The Woodland Trust
Kempton Way
Grantham
Lincolnshire
NG31 6LL

14th December 2021

Reference: A417 Missing Link

Drawing Title: **FIGURE 13.19 SCHEME HIGHWAY DRAINAGE - PLAN**

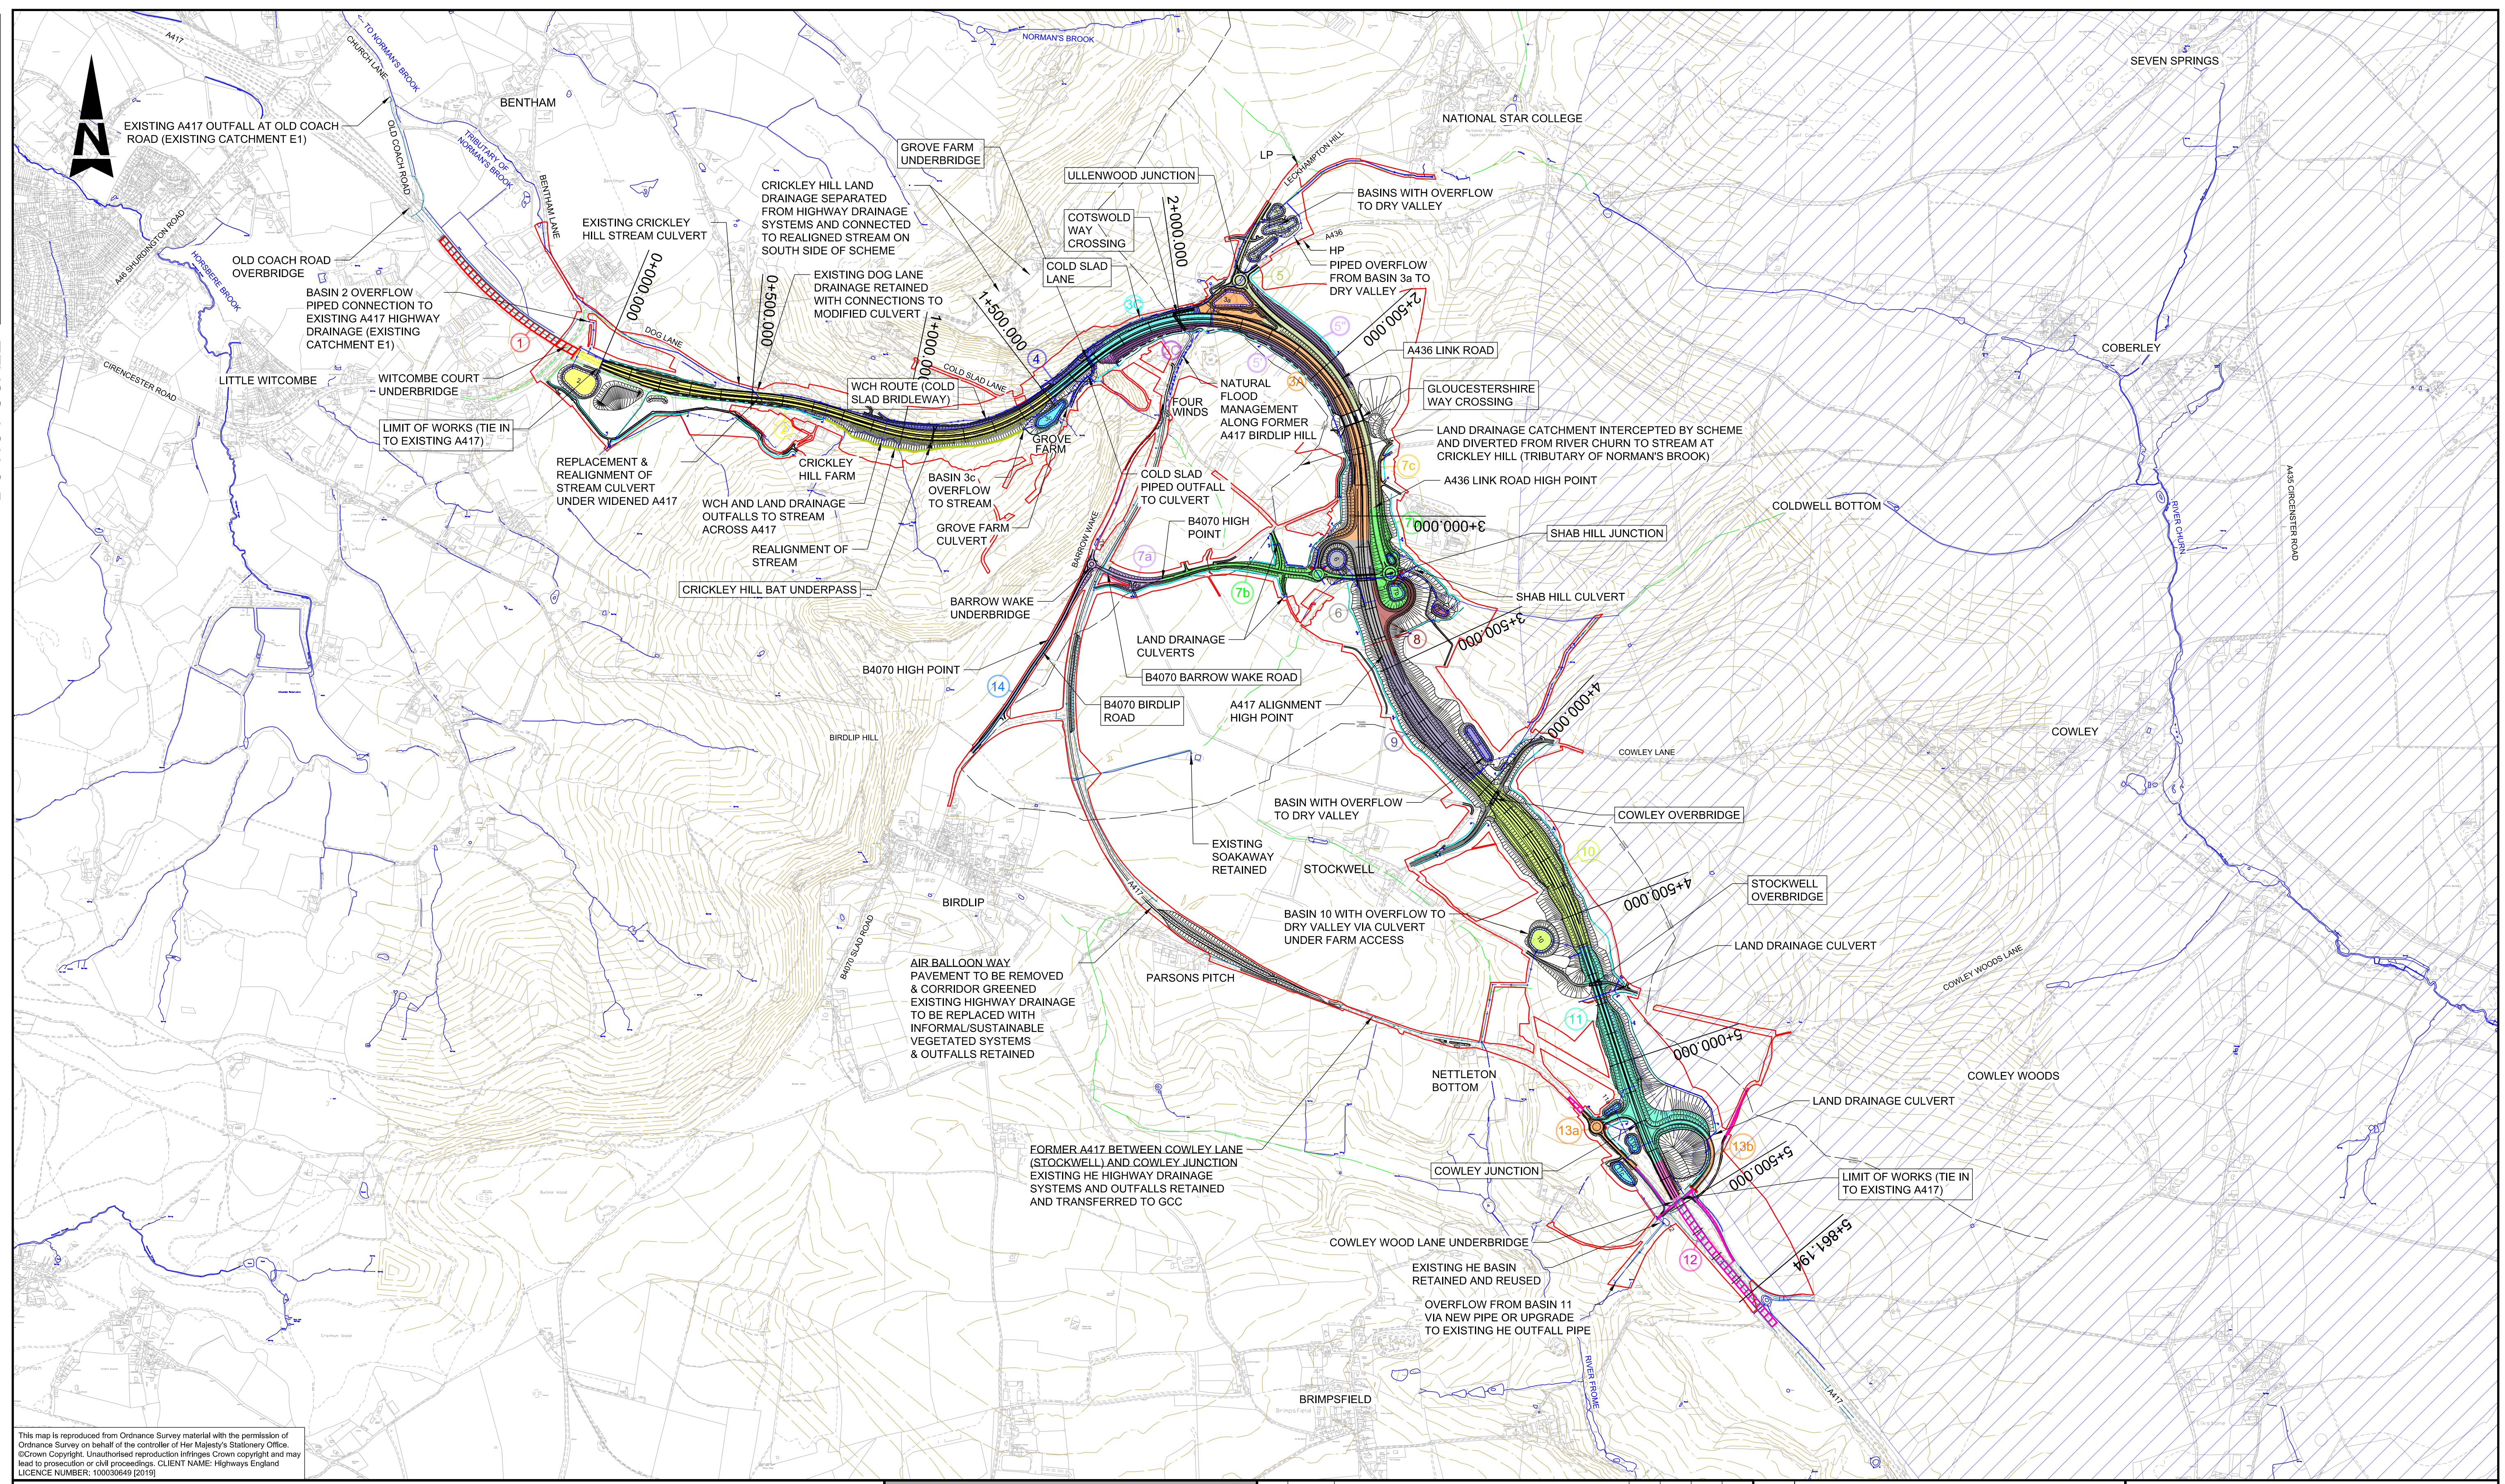
nos: 143975 and 143988) are located within the path of the proposed highways drainage area, which is likely to result in adverse hydrological impacts from the change in both water quantity and quality.
